RFI

RFI #: 80  
Date: 3/20/2012  
Job: EB-02 Keller Springs Lofts  
Phone: 877-777-5115

Subject: Elevation conflict with floors

DATE	08-05-2011	SHEET NUMBER	3.1
PROJECT	11129

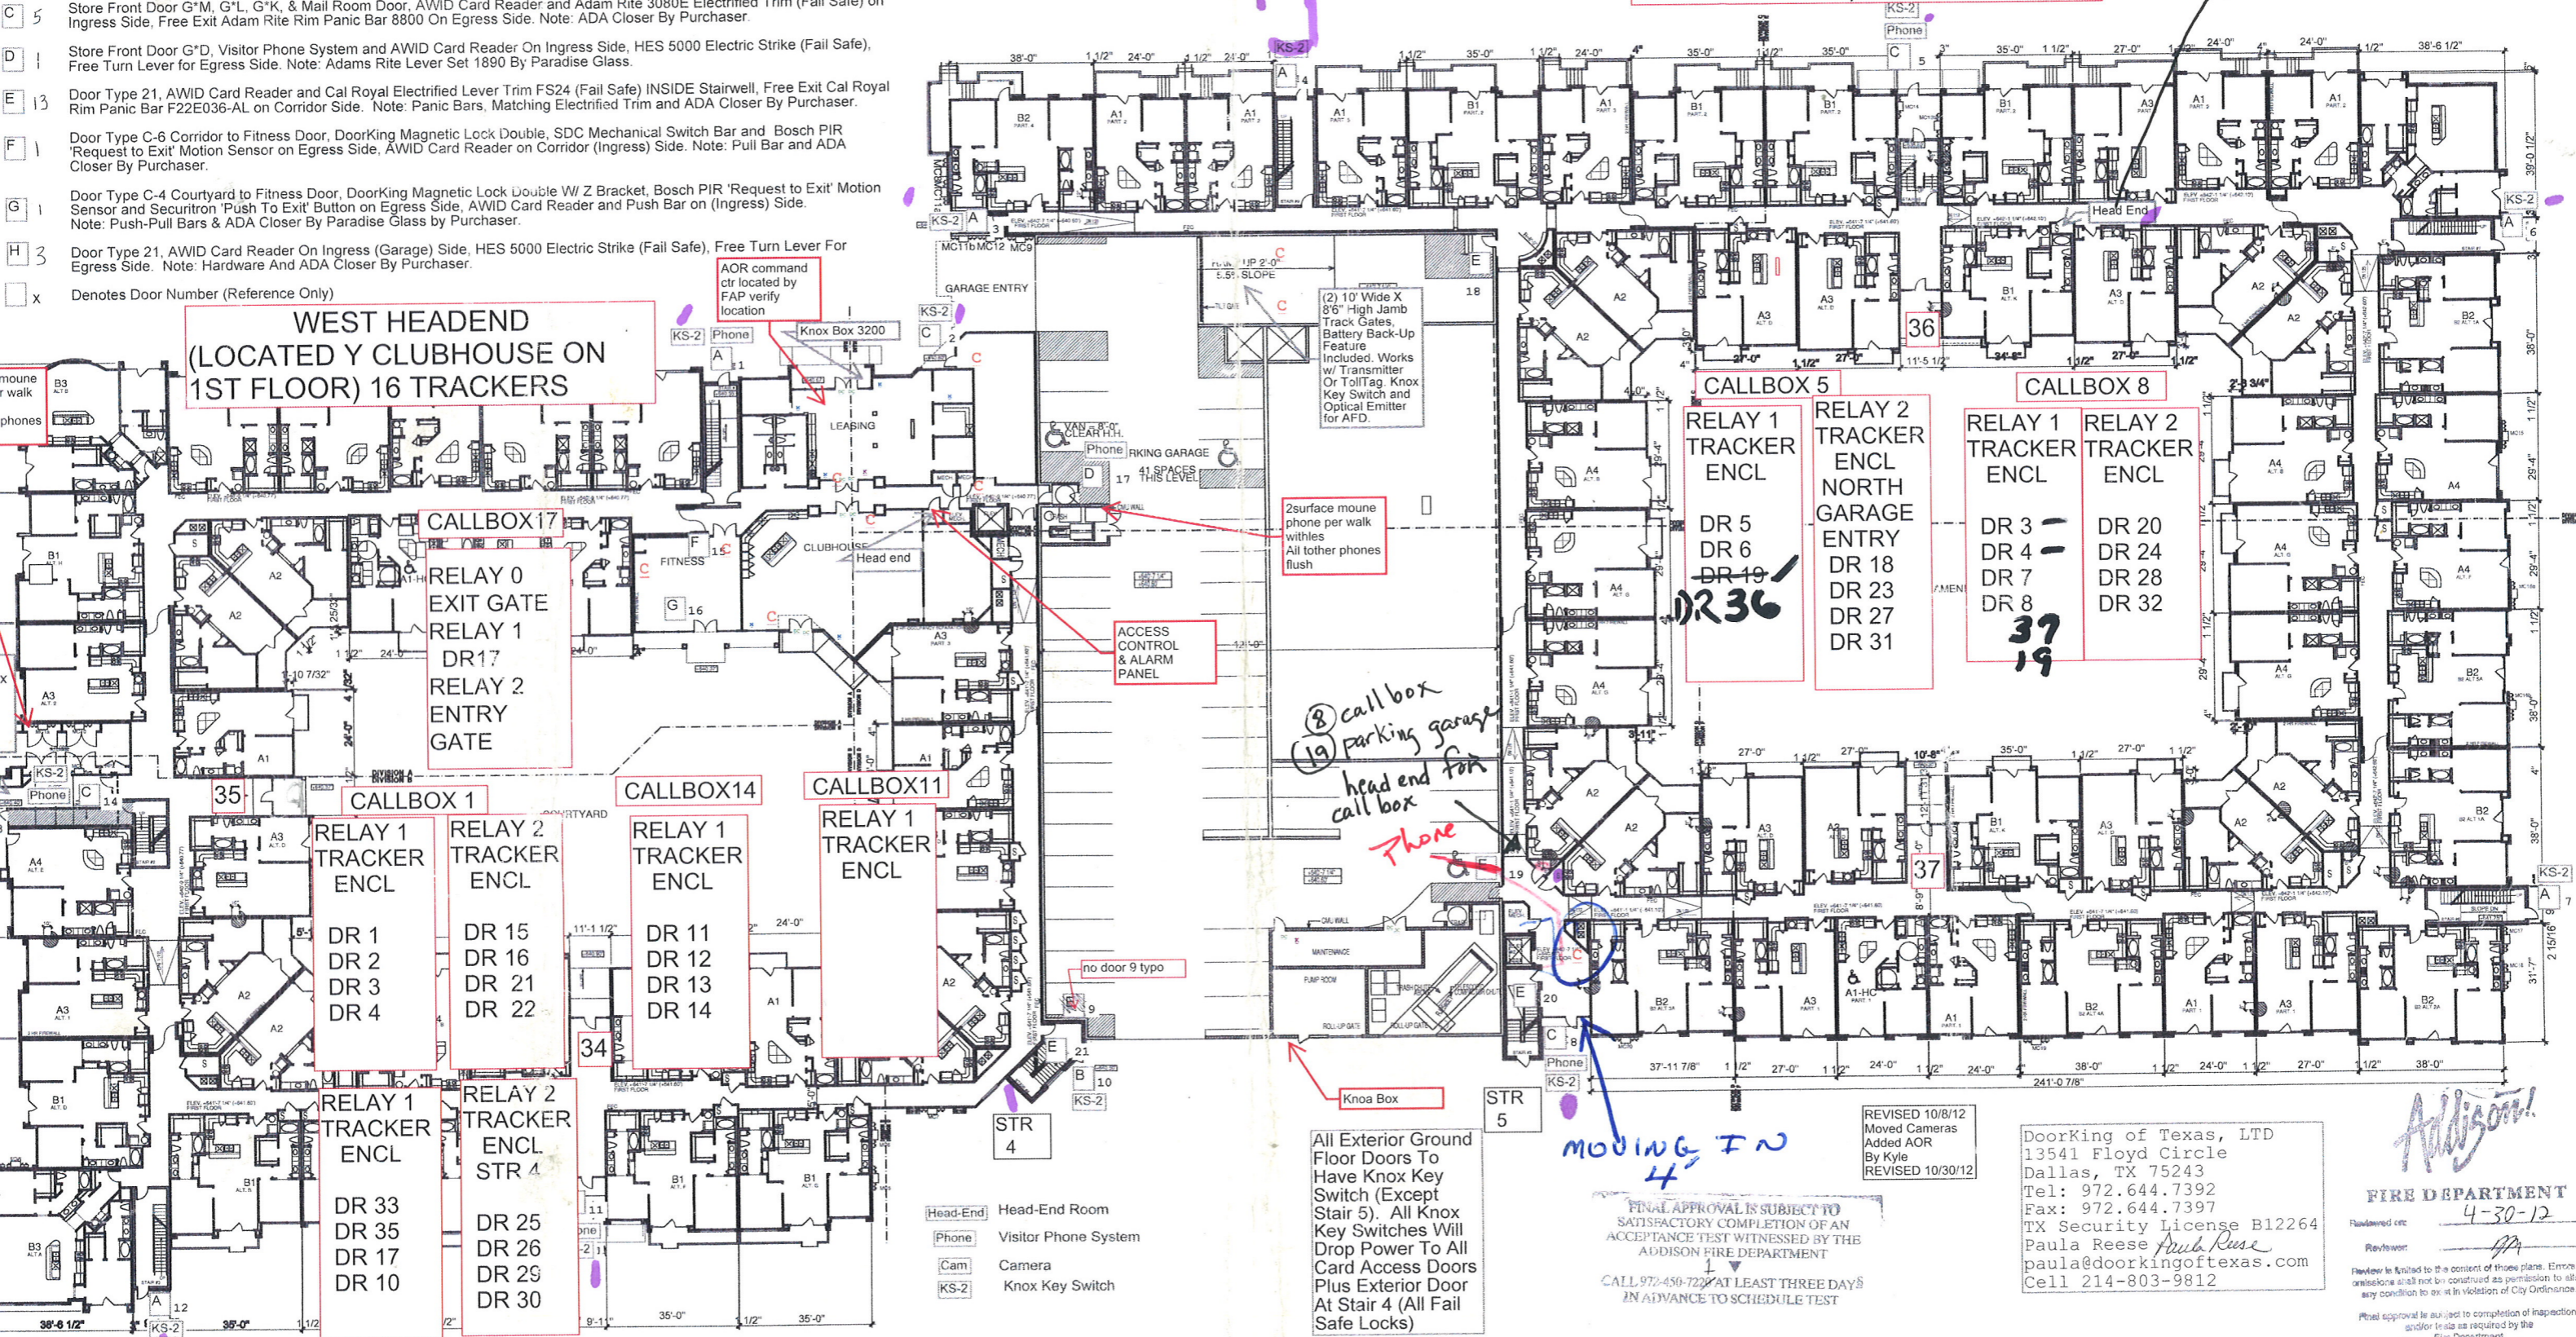
Thank you for addressing RFI #48. Your answer to #48 has us installing an additional 1x to the bottom plate to achieve specified elevations at 2nd 3rd and 4th floors around the parking garage. We do agree with adding the 1x to 2nd and 3rd floor bottom plates, but we think it should be to the entire 2nd and 3rd floors. The problem that we resolved around the garage is still present at the other stairwells. Here is a list of potential problems with installing the 1x to only parts of the floor

- 1 we will have step downs in the corridor ceilings
- 2 we will still have elevation problems at stairwell #s 1-2-3-6-7-8
- 3 floor plate differences at exterior elevations
- 4 the ramping of the floors (that you have addressed)
- 5 we will have to add a 1x to top of 4th to all areas not raised or field out all of the studs in your shaded area to achieve proper roof truss bearing.

In summary we think that we should install the 1x to all of 2nd and 3rd floor bottom plates. Erik this was previously discussed with the Project Manager David Gallagher, the Project Super Brian Peterson and with you and agreed upon by all parties.

Response: BGO agrees and has no exception to this change.
